Recommendation Report for Planning Permission for Works or Extension to a Dwelling

REF NO: BR/207/18/HH

LOCATION: 84 Brooks Lane
Bognor Regis
PO22 8DN

PROPOSAL: Single storey side extension

Plan. [As Rep'd]

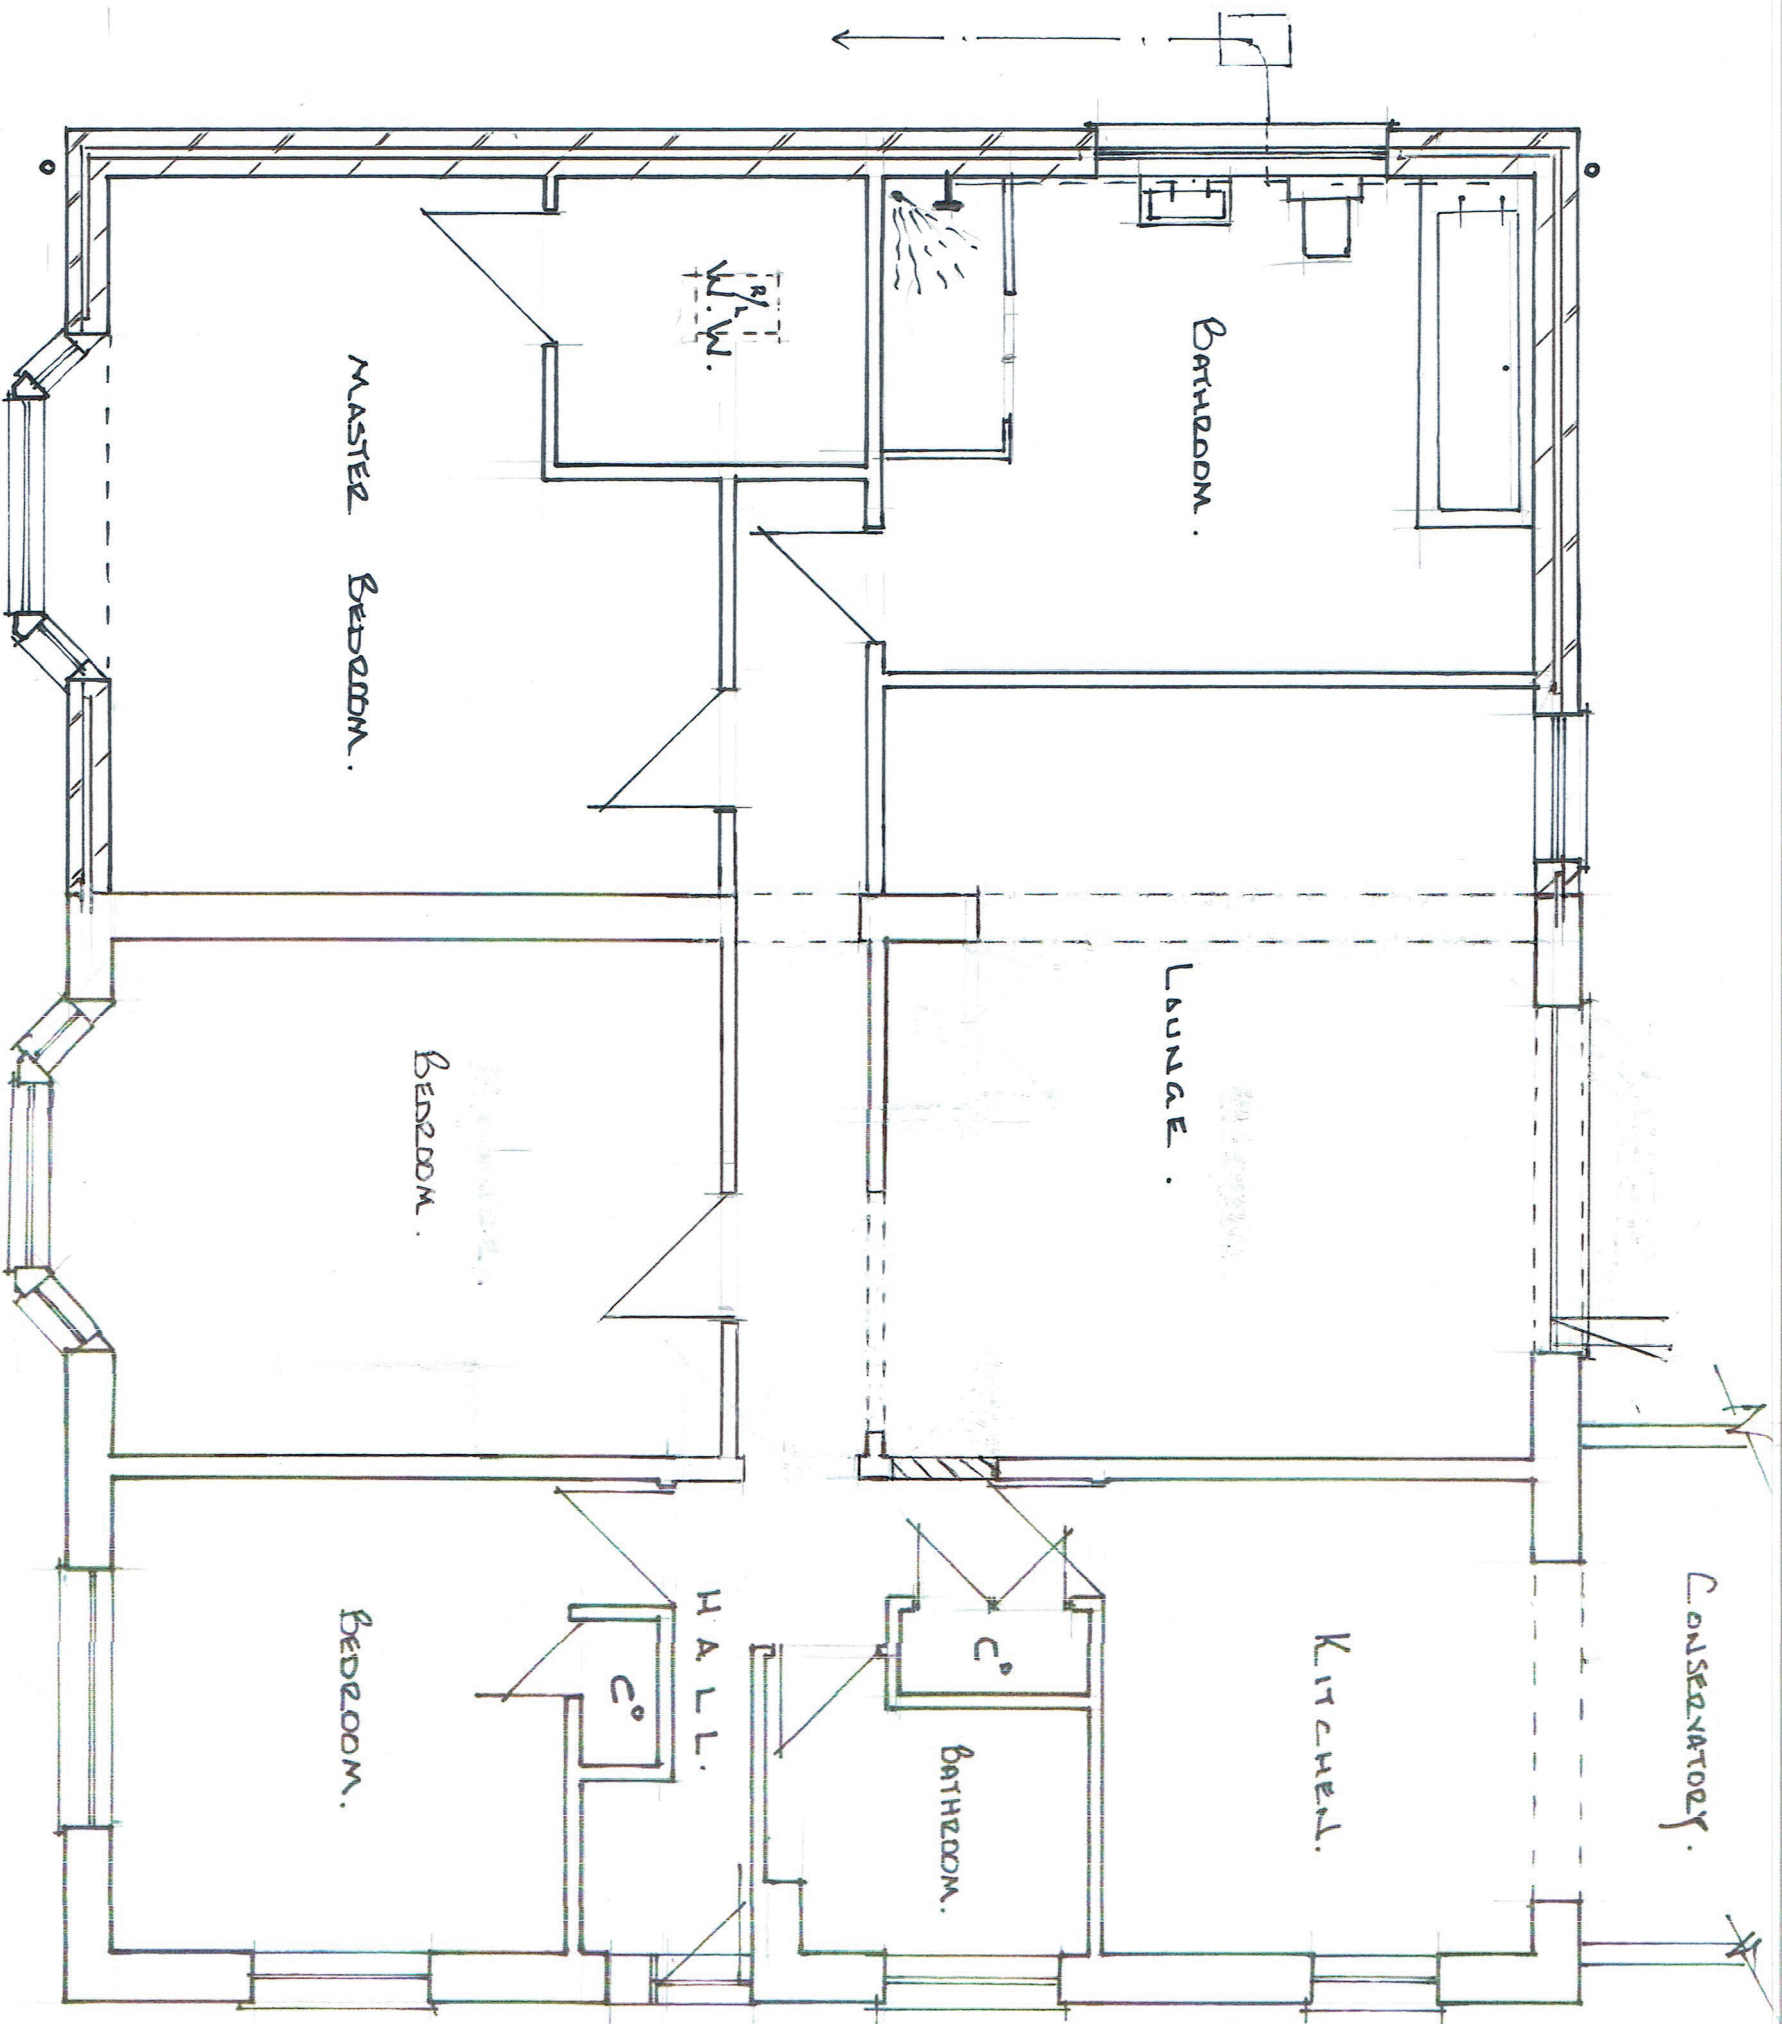
It should be noted that on the Block Plan the distance from the Eastern boundary to the proposal should be 10m and not 4m as indicated on the plan.
